Order Granting Development Consent for Tween Bridge Solar Farm at land either side of the M180, High Level Banks (the A18) and the Stainforth and Keadby Canal (EN010148)

Deadline 4: Representations on further information submitted at Deadline 3

3.0 Biodiversity Net Gain (BNG) Assessment (Rev 3) [\[REP3-028\]](#)

Figure 2 : 16413_P19_Post Development Habitats_TLR_RR

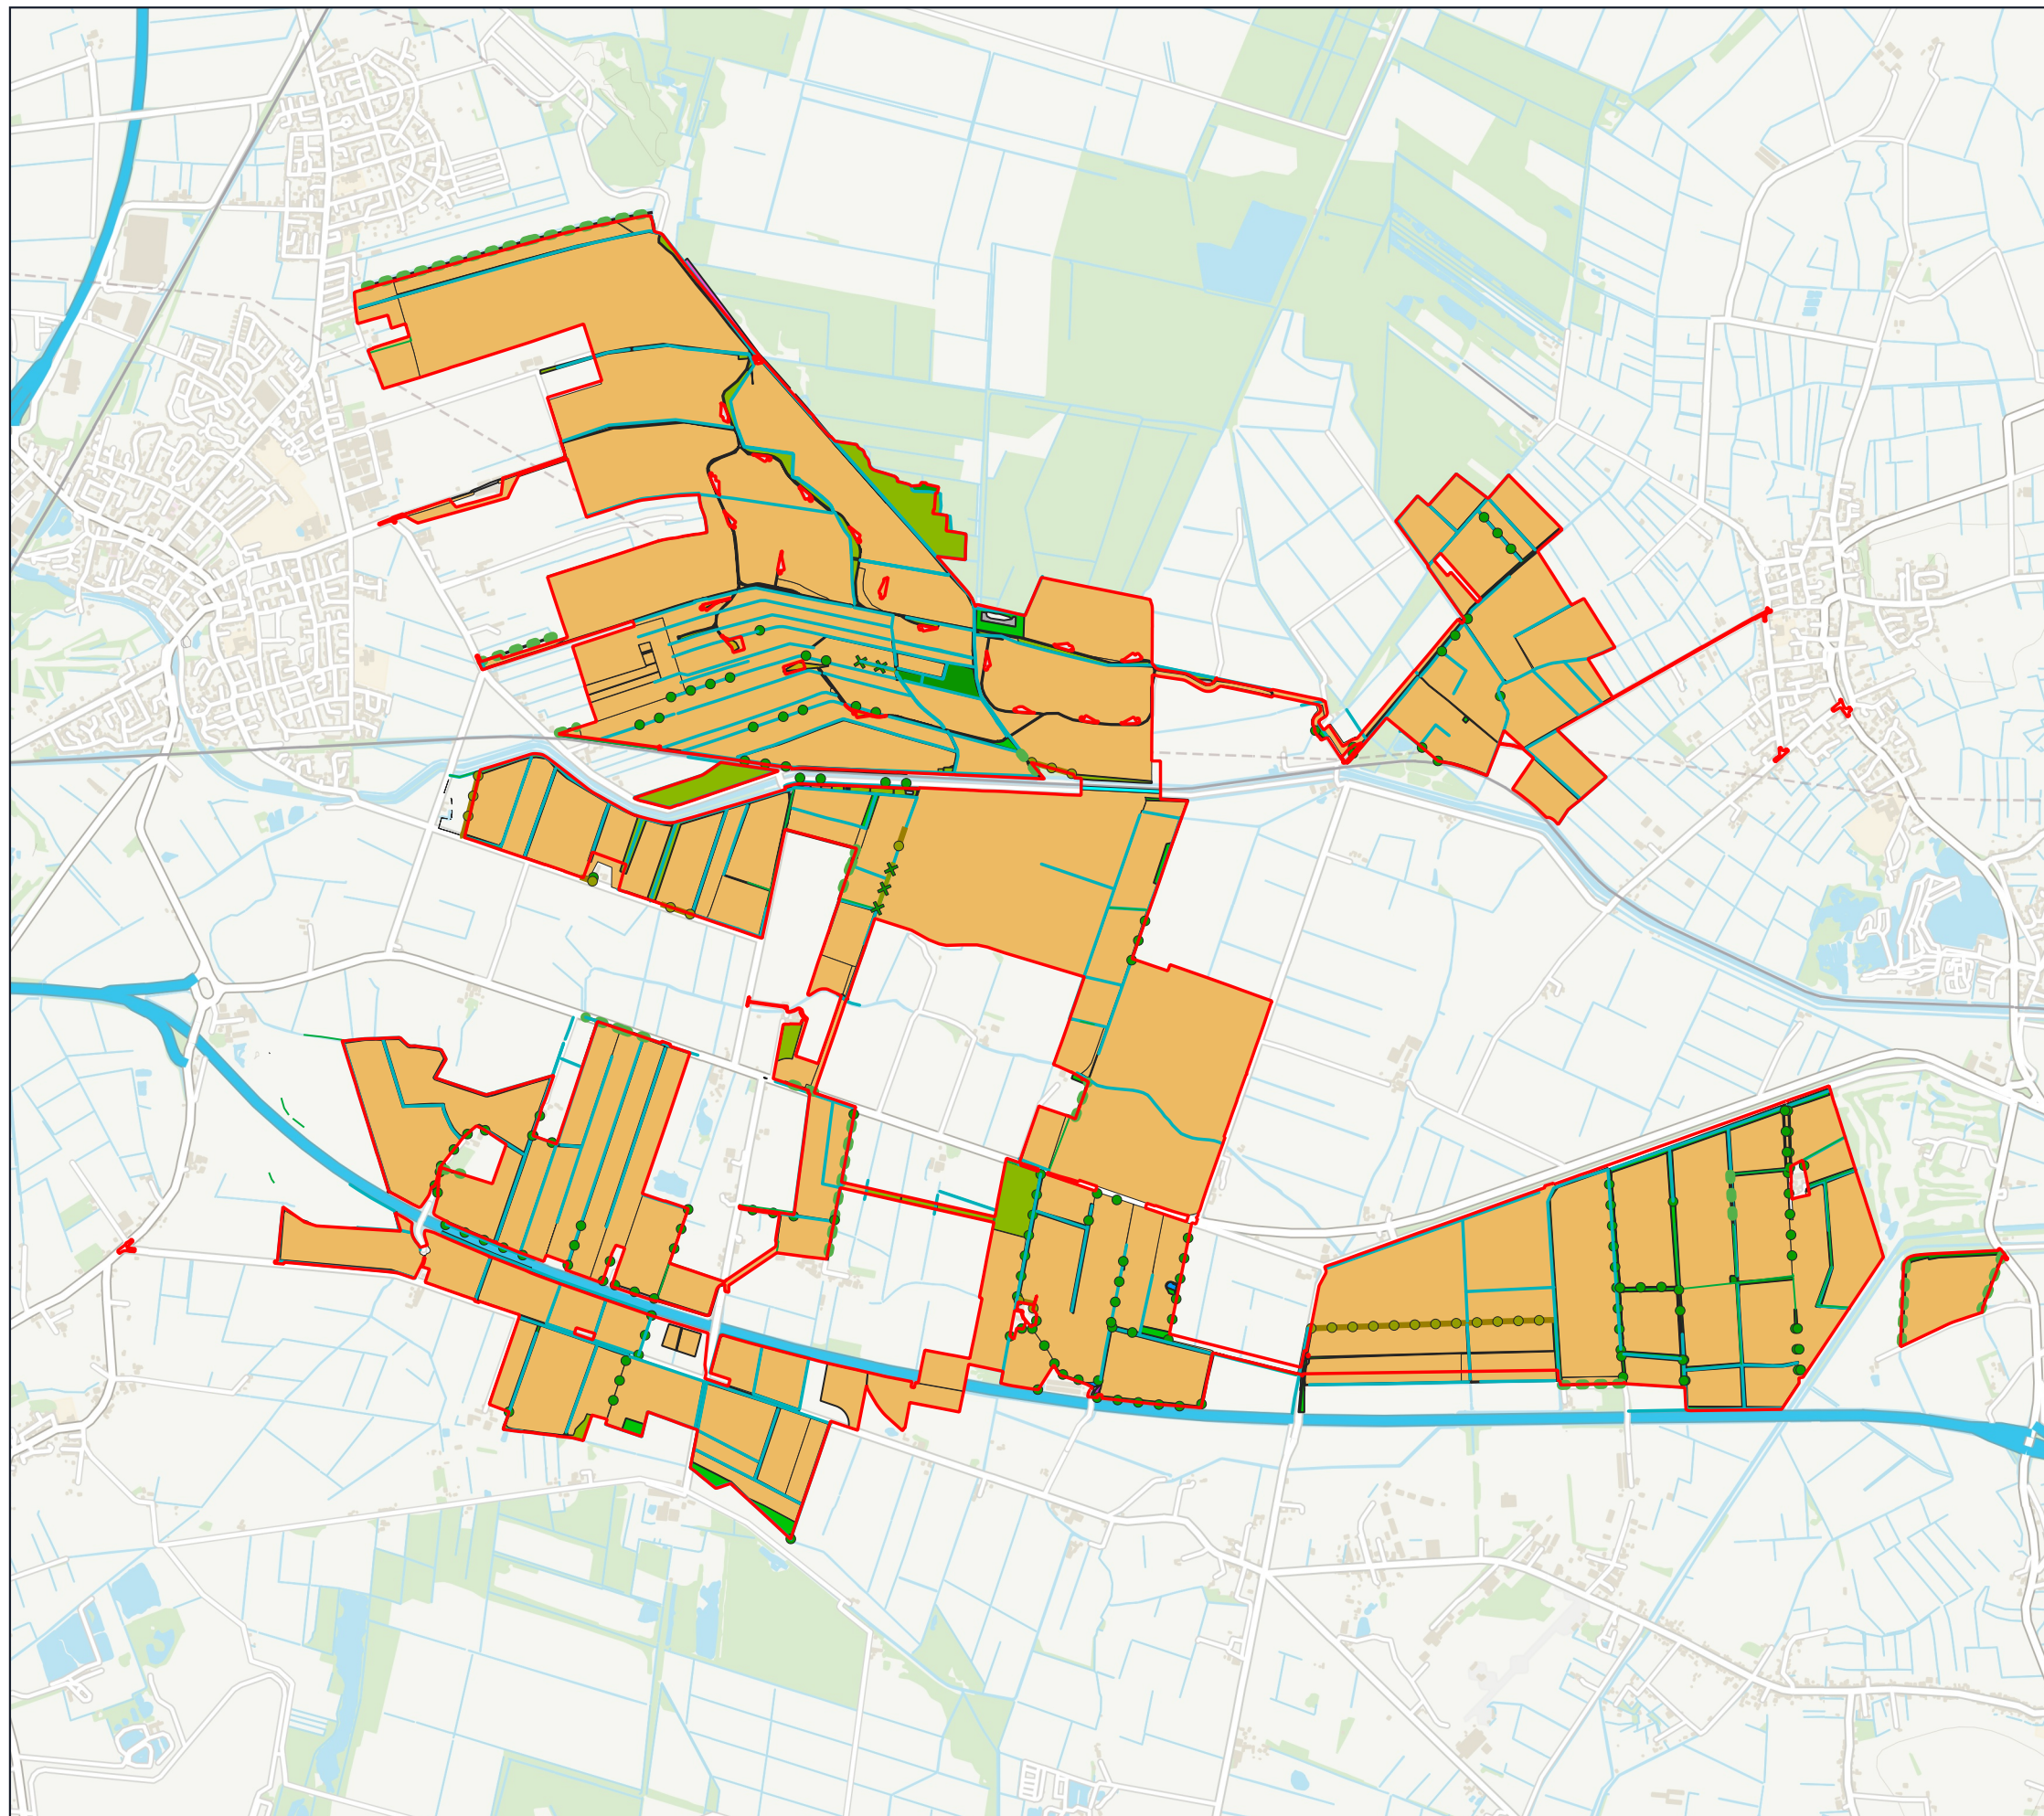
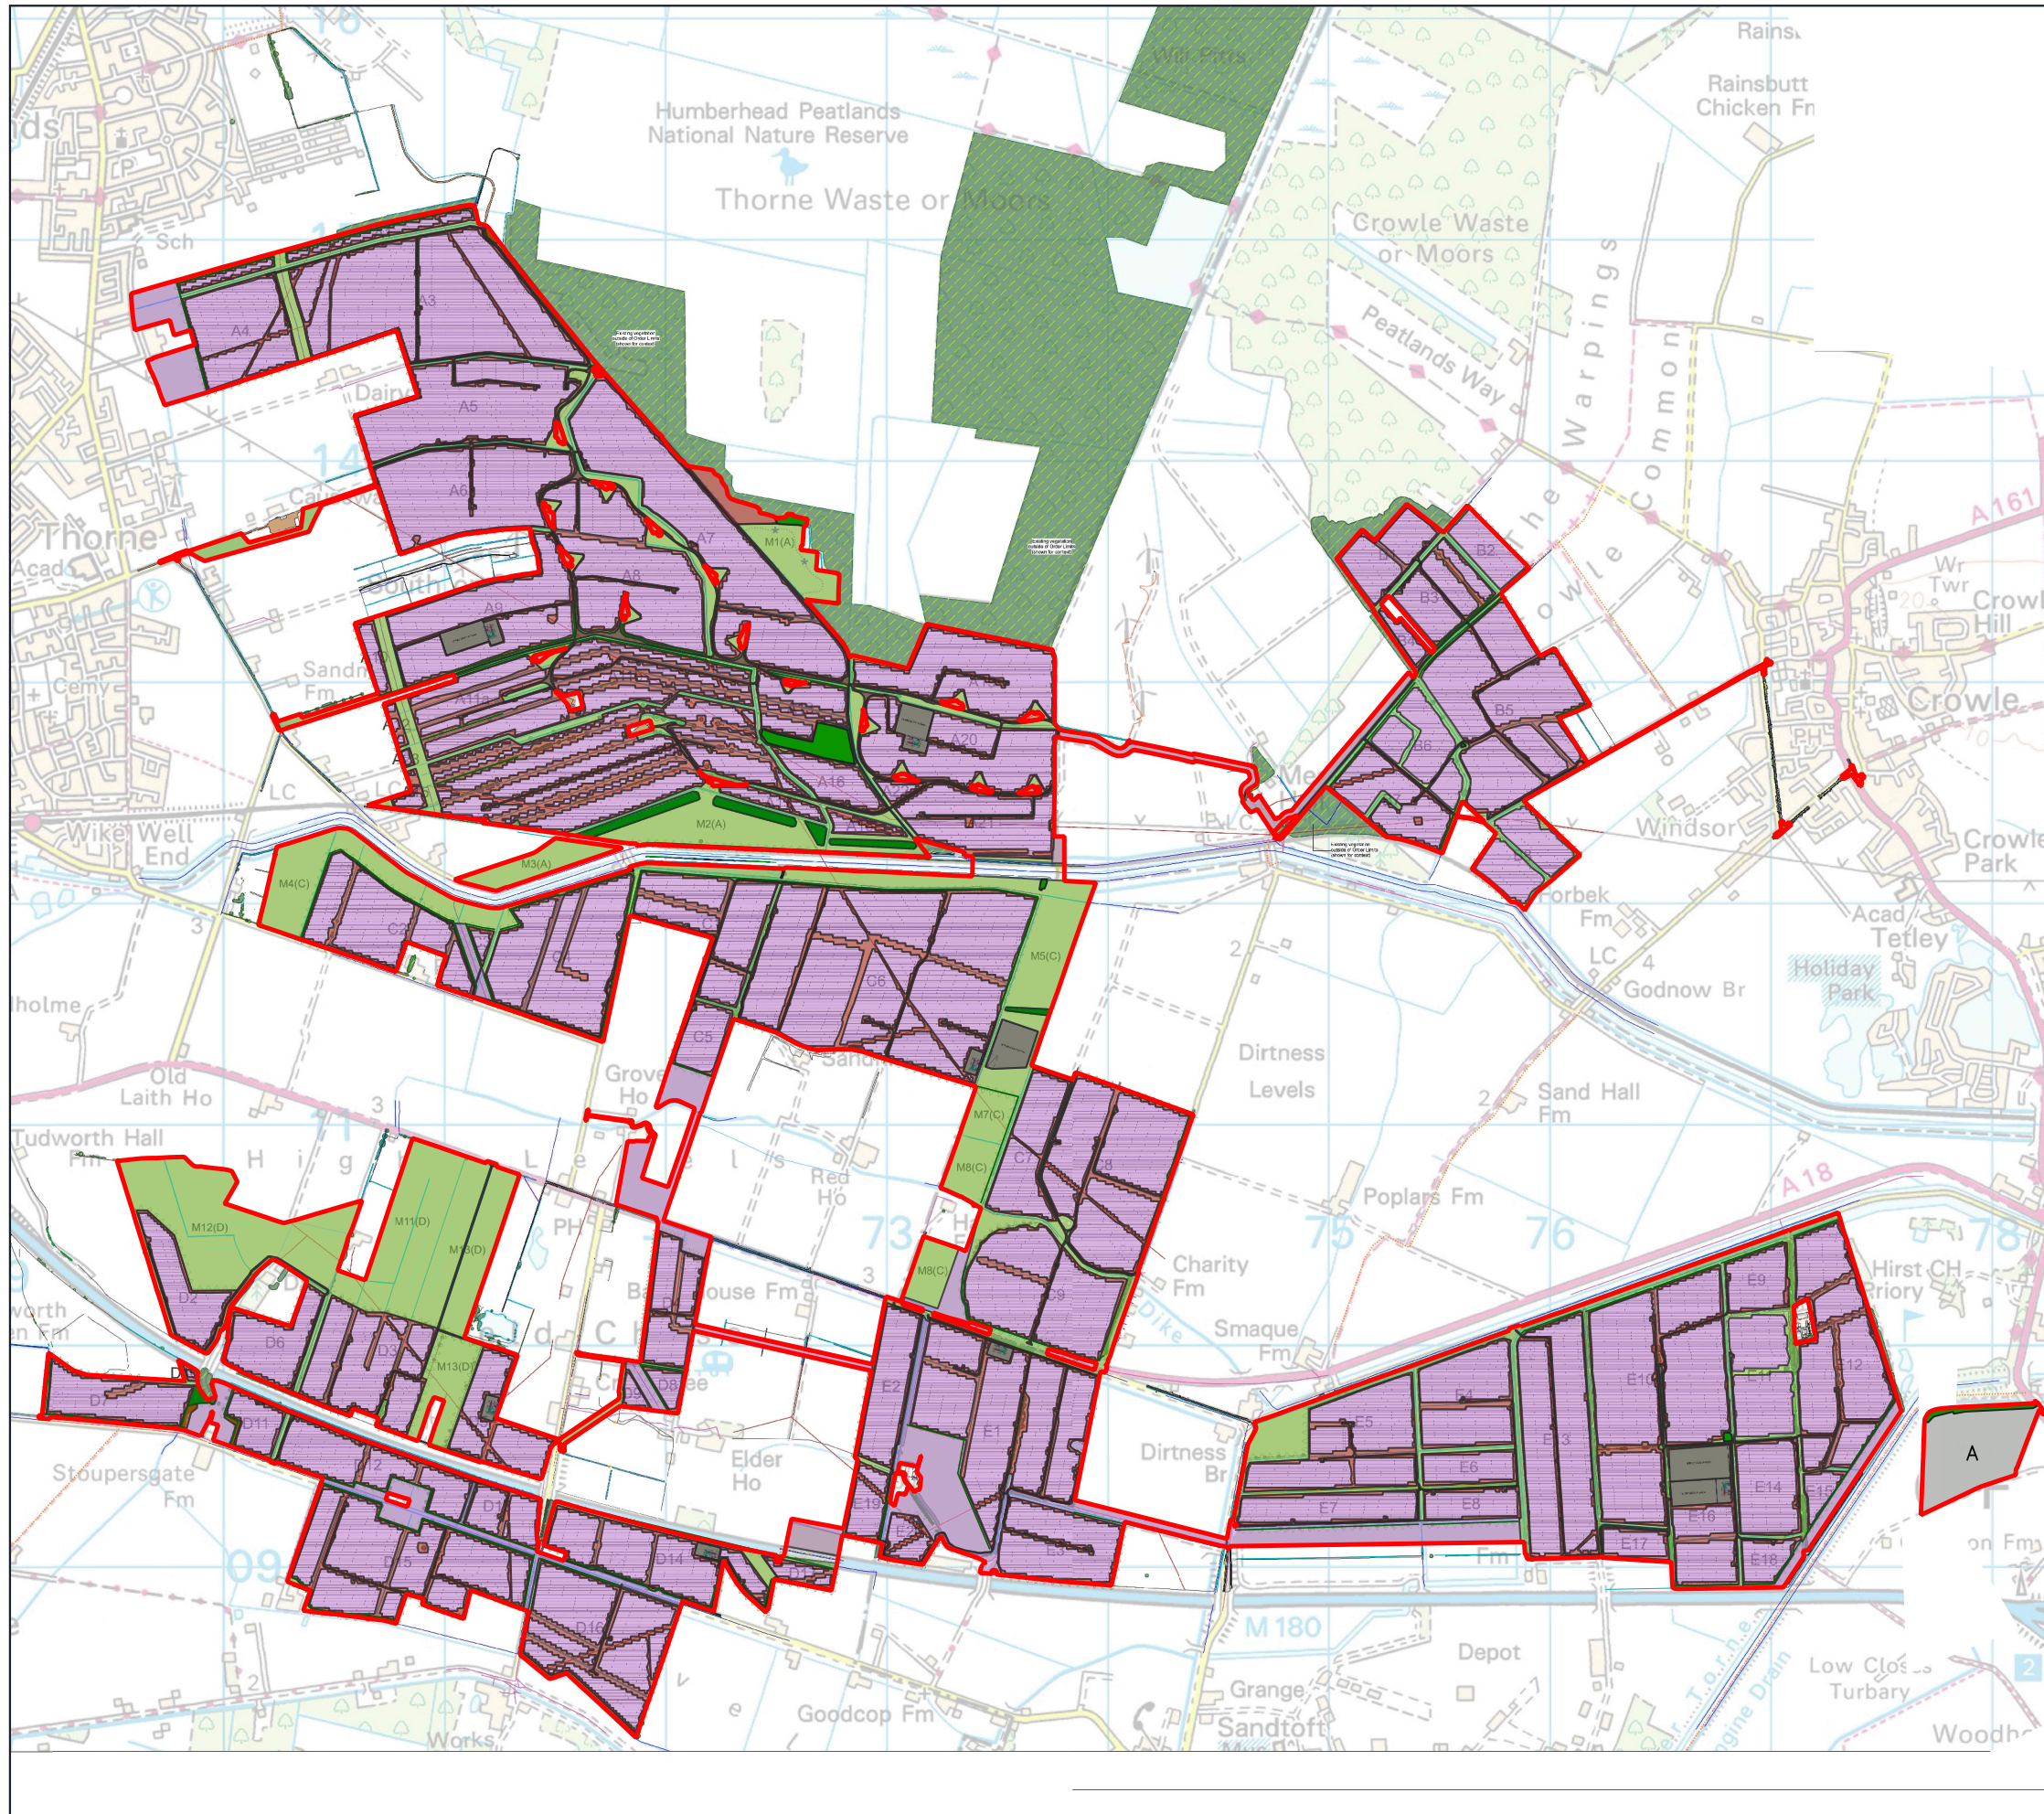
- 3.1 The Environment Agency has reviewed the revised BNG Assessment and the Statutory Biodiversity Metric Calculation Tool [\[CR1-002\]](#) submitted as part of Change Request 1. In our Deadline 1 Written Representations [\[REP1-064\]](#) we outlined that Paragraph 2.12 of the BNG Assessment states that all ditches are to be retained and enhanced, but this was not reflected in the Metric. The submitted Metric still does not appear to reflect the BNG Assessment in this regard. The BNG Assessment also refers to slightly different figures for net gain compared to those included in the Metric.

- 3.2 In our previous representations, we also advised that the Metric did not appear to take into account impacts to existing culverts and new culverts. In line with The Statutory Biodiversity Metric User Guide (June, 2026), we consider that any new culverts should be recorded as lost. The updated Metric includes a note on tab 10, referring to 45 new culverts but it does not record any length of watercourse or units lost. This conflicts with the advice in the BNG Metric User Guide.

- 3.3 As noted in our Deadline 2 Written Representations [\[REP2-102\]](#), it is unclear whether the BNG Metric is complete due to there being no information on the Watercourse Creation tab. We consider it likely that additional enhancements may be required to ensure delivery of 10% net gain for watercourses.
